Application for a non-material amendment following a grant of planning permission.

Variation of condition 1(k) and condition 15 imposed under FP/92/04/ for bus gate (approved Phase 2) to be replaced with an emergency services vehicles access gate and a bicycle link.

Reference number: FP/239/19/PL

10140/SK01 Rev C3 Emergency Access and Cycle Link

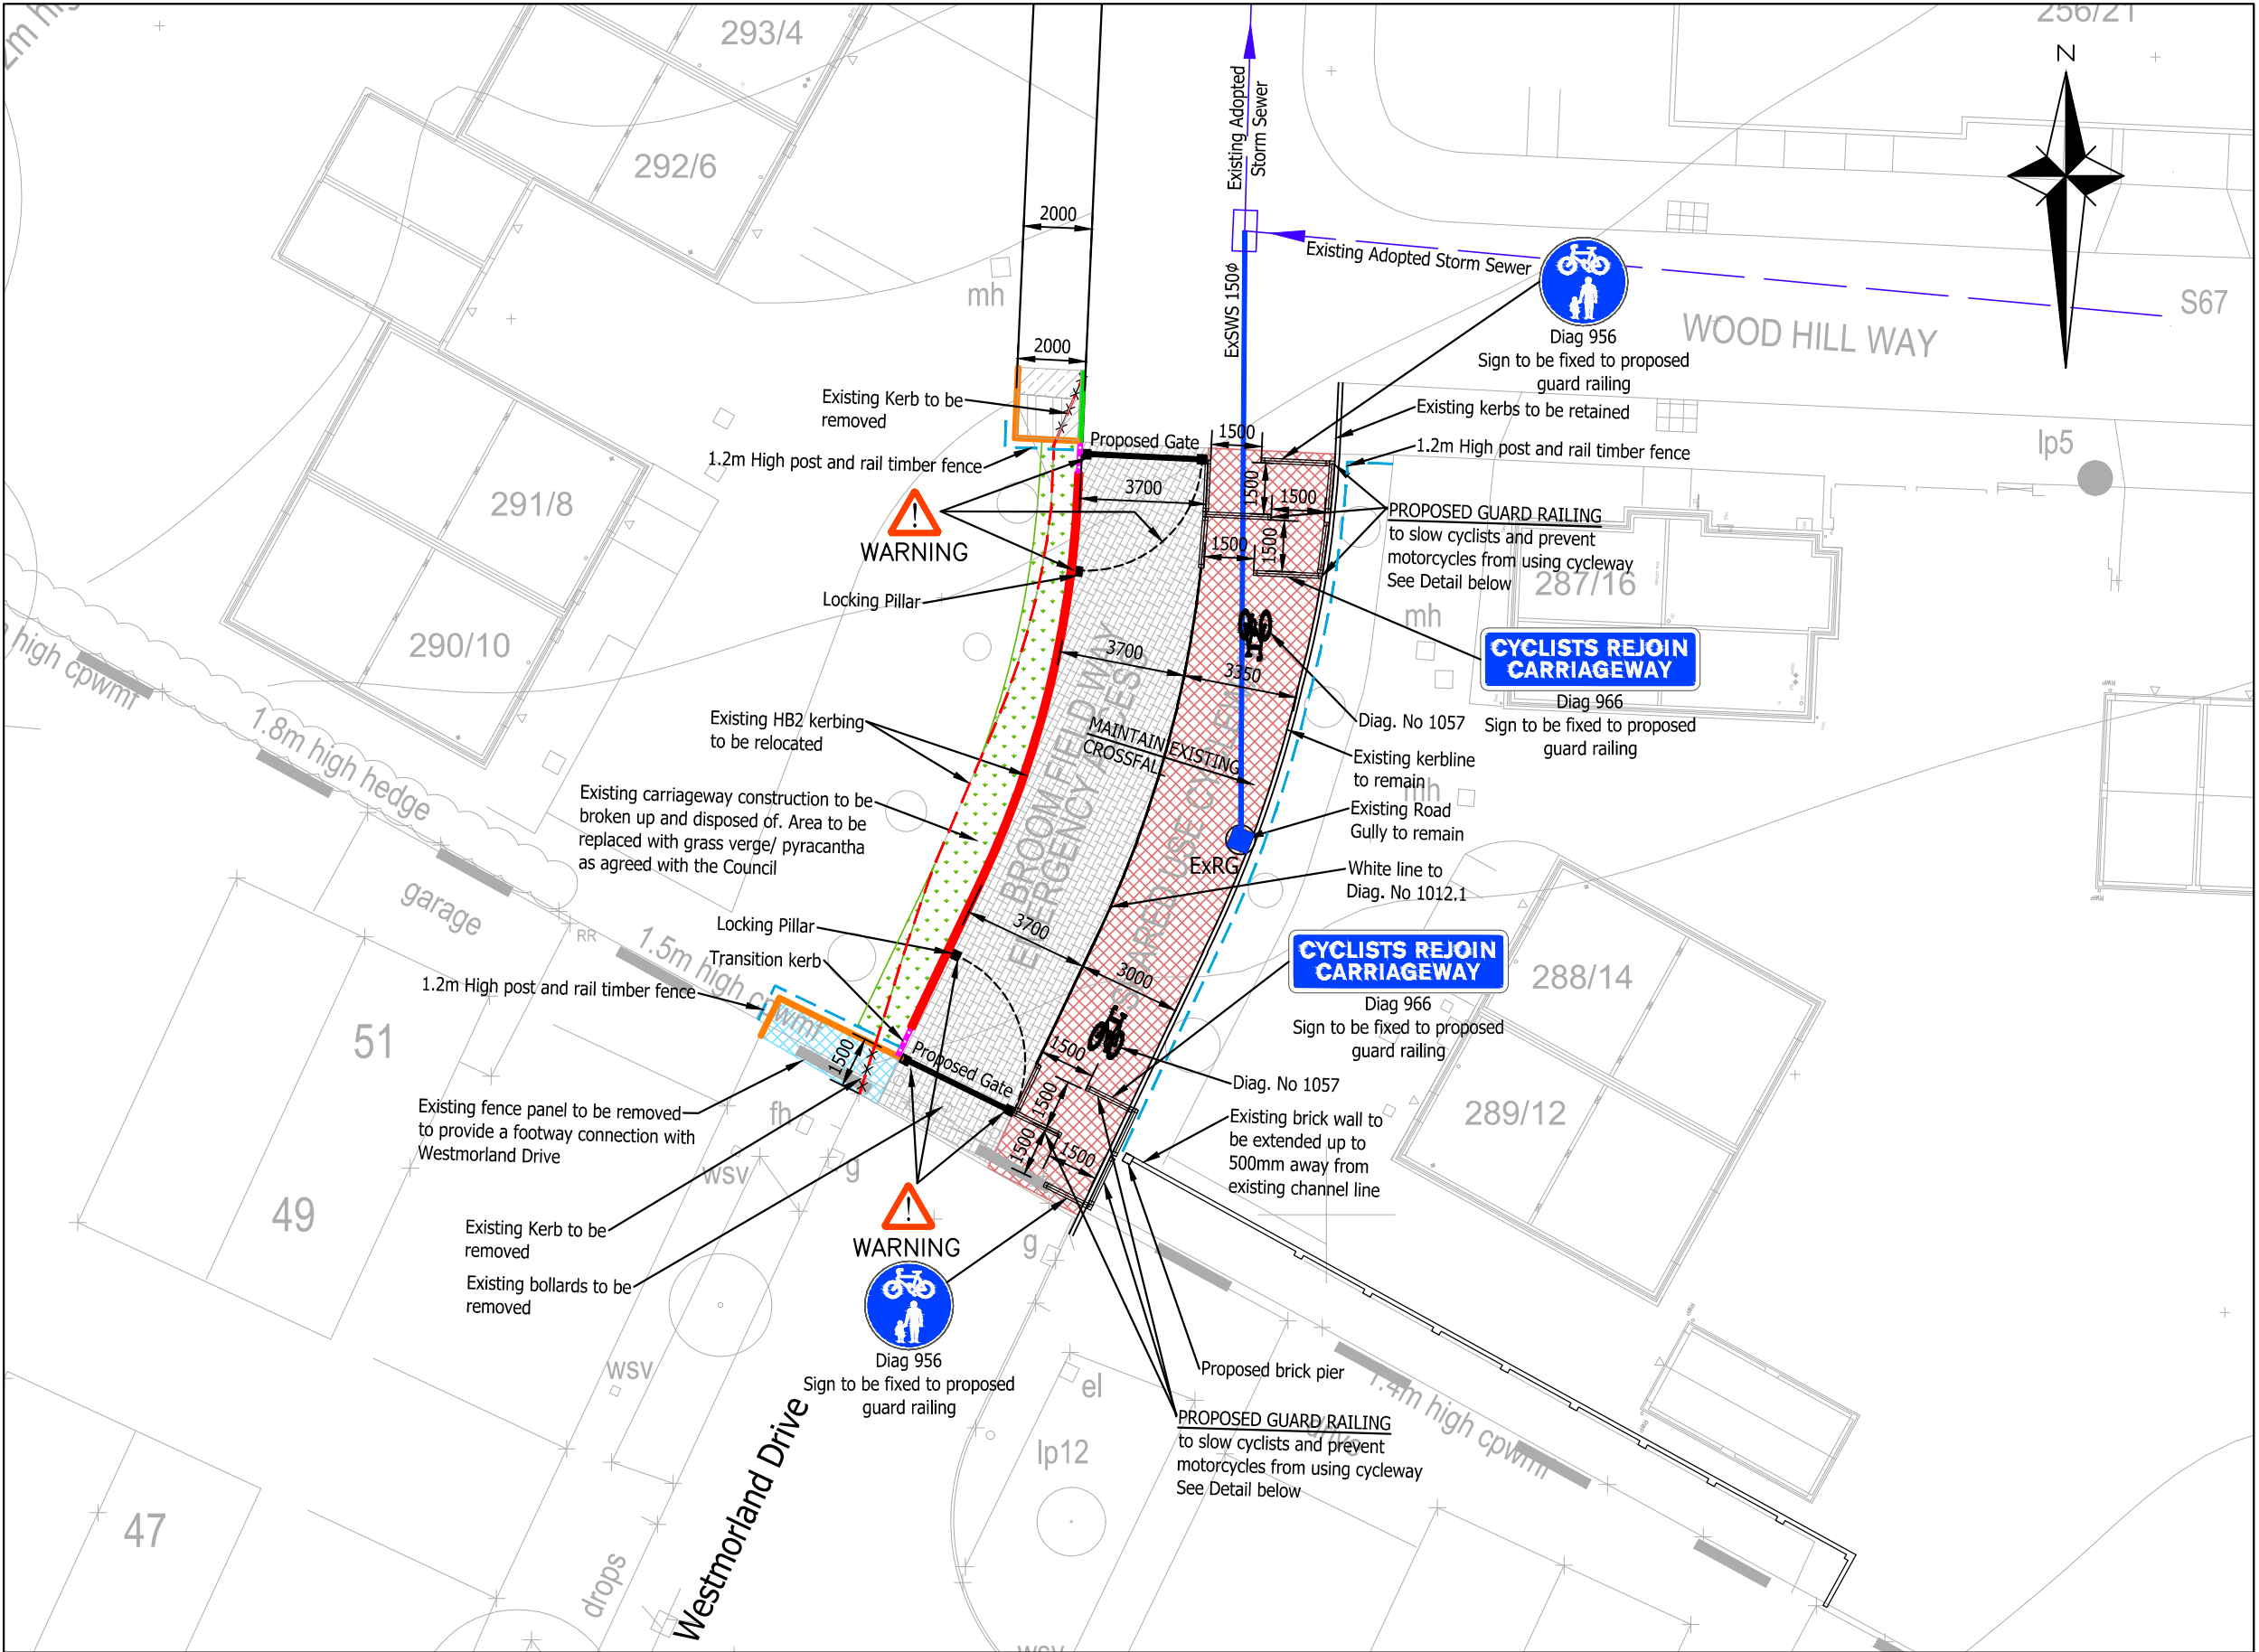
-Replace small section of 1.2m close board fence with 1.2m post and rail fence
-Addition of guard railings adjacent to northern gate
-Gate colour to be amended from grey to yellow

Safety improvements to approved cycle way
